Our ref: SSD-5544-Mod-7

**Subject: Additional Matters for Response to Submissions Report – Infrastructure consolidation and remediation, Kurnell Refinery Conversion (SSD-5544-Mod-7)**

## **Attachment 1: The Department's comments on the Modification Report**

**FIGURE F3:
FIRE WATER SYSTEM AND
OILY WATER SEWER**

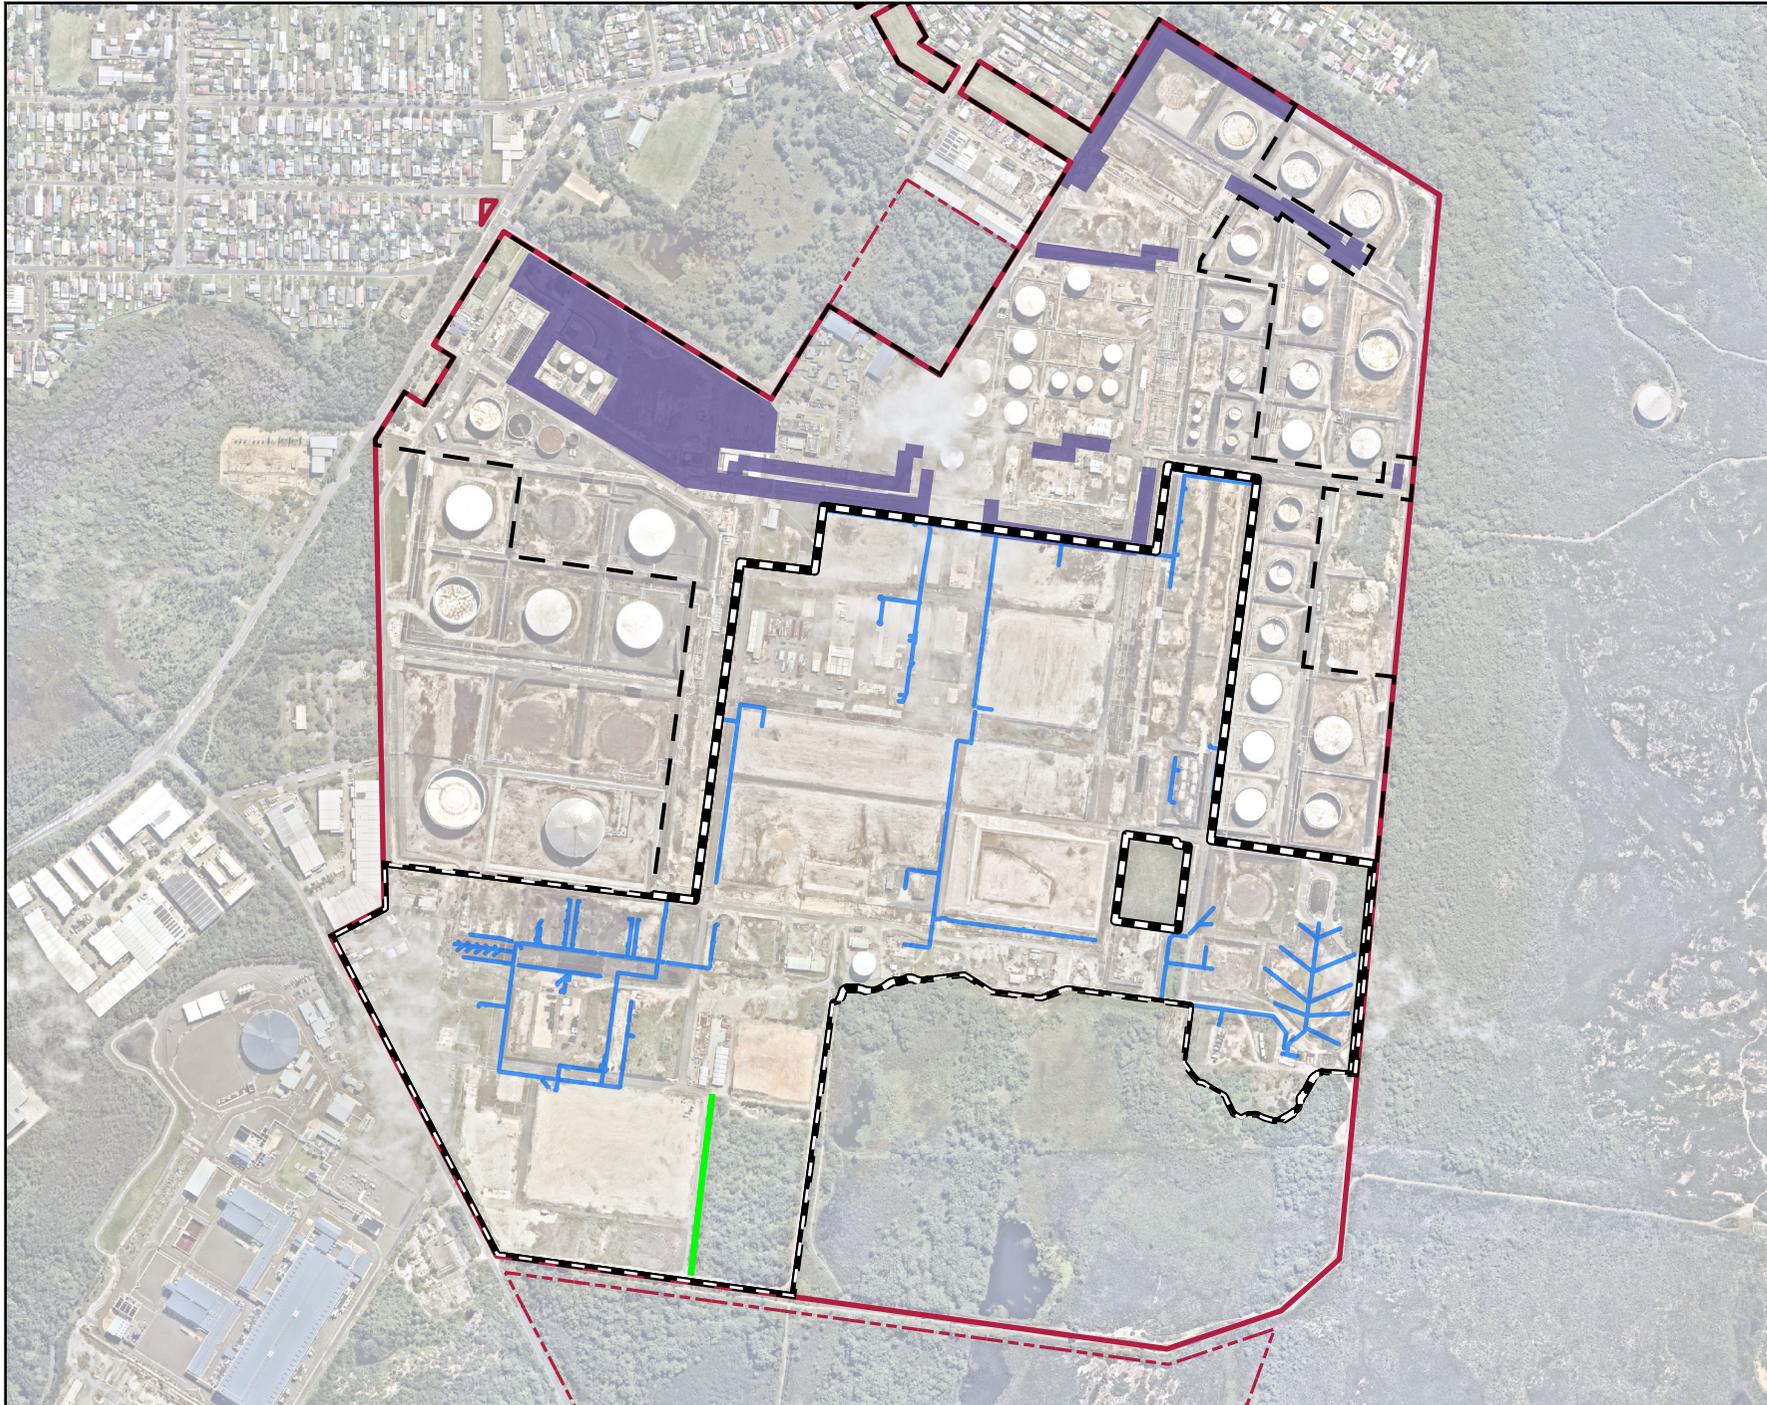
4. Text on page 28 of the Modification Report indicates that the Firewater system (FWS) is proposed to be removed or augmented from Zones 2 and 3 of the site, and augmented in Zone 1, however wording is unclear in some sections re. what is proposed (e.g. *“If removed in Zone 2, installation of new firewater pipelines, relocated pumps ...”*, *“If required, the FWS would be relocated to one of the two siting options”*). Please clarify what is proposed regarding the FWS, and where there are multiple options, describe and assess all options being considered.
